MECKLENBURG COUNTY

Park and Recreation Department

MEMORANDUM

RE: Rezoning Petition #2023-001
PID# 07112129

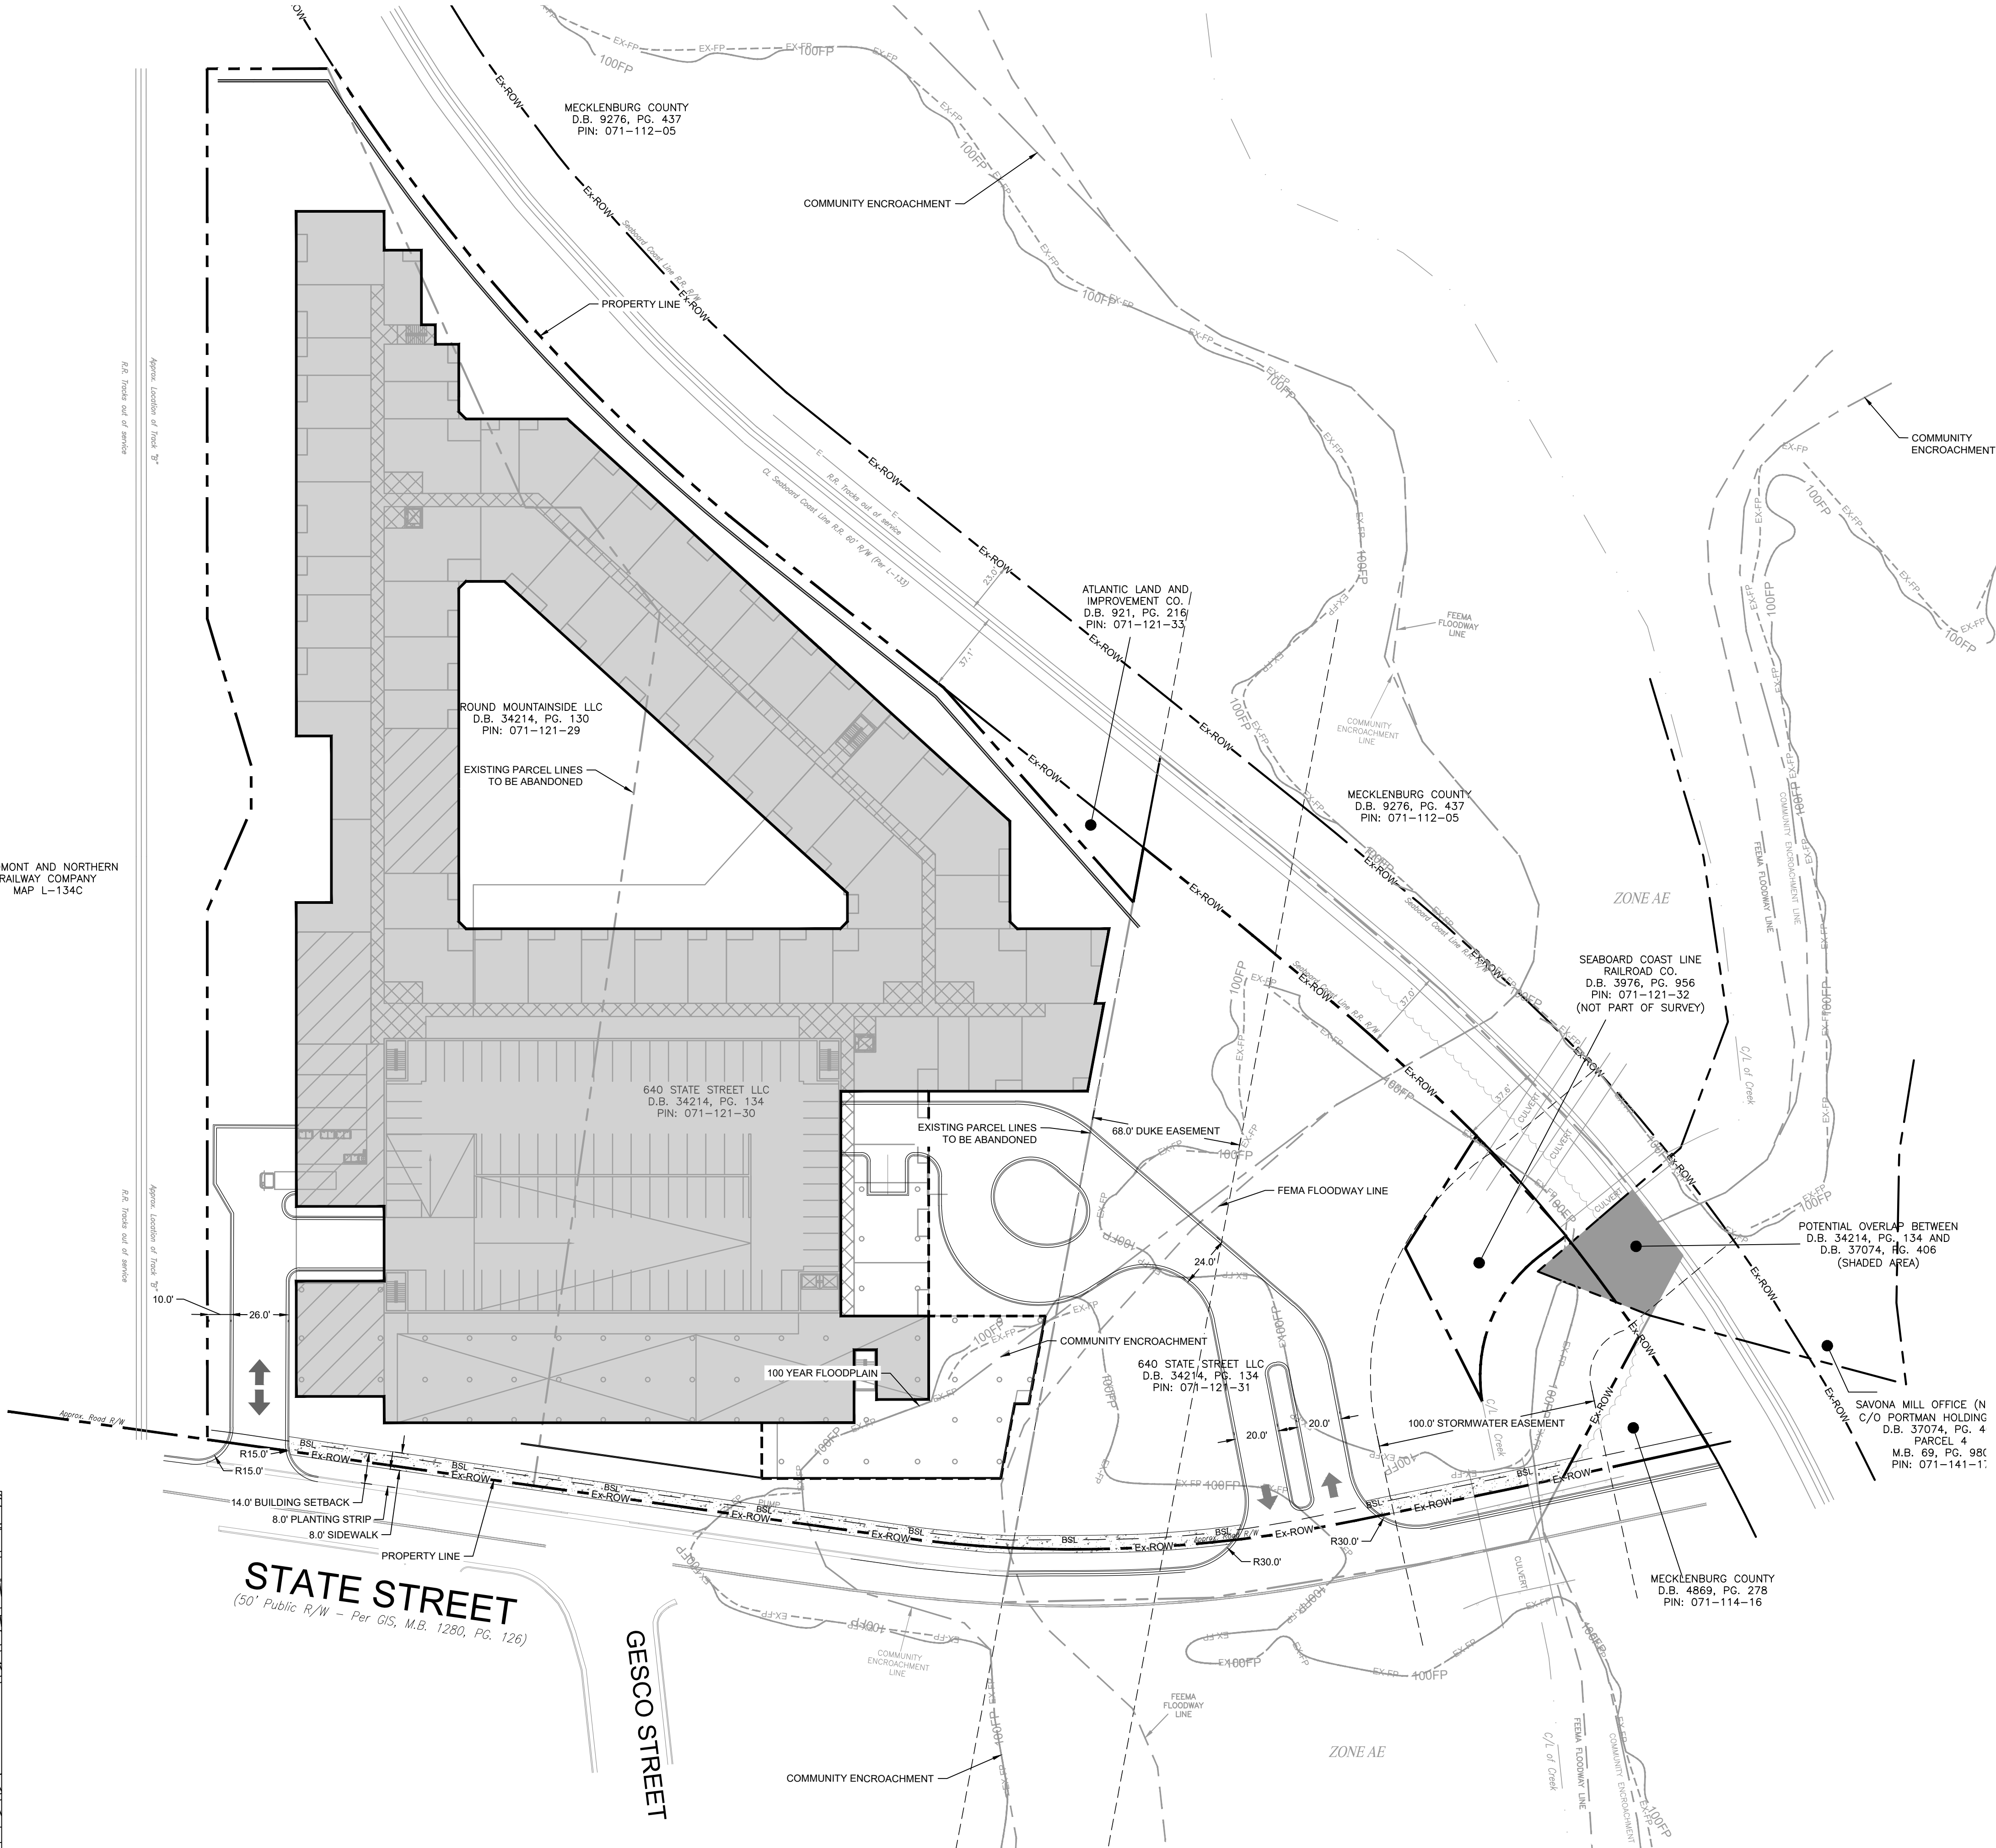
MCPR requests a pedestrian walk from the proposed building to the public sidewalk on State Street and extend the existing sidewalk on State Street to connect to the existing Stewart Creek Greenway/crosswalk to the east.
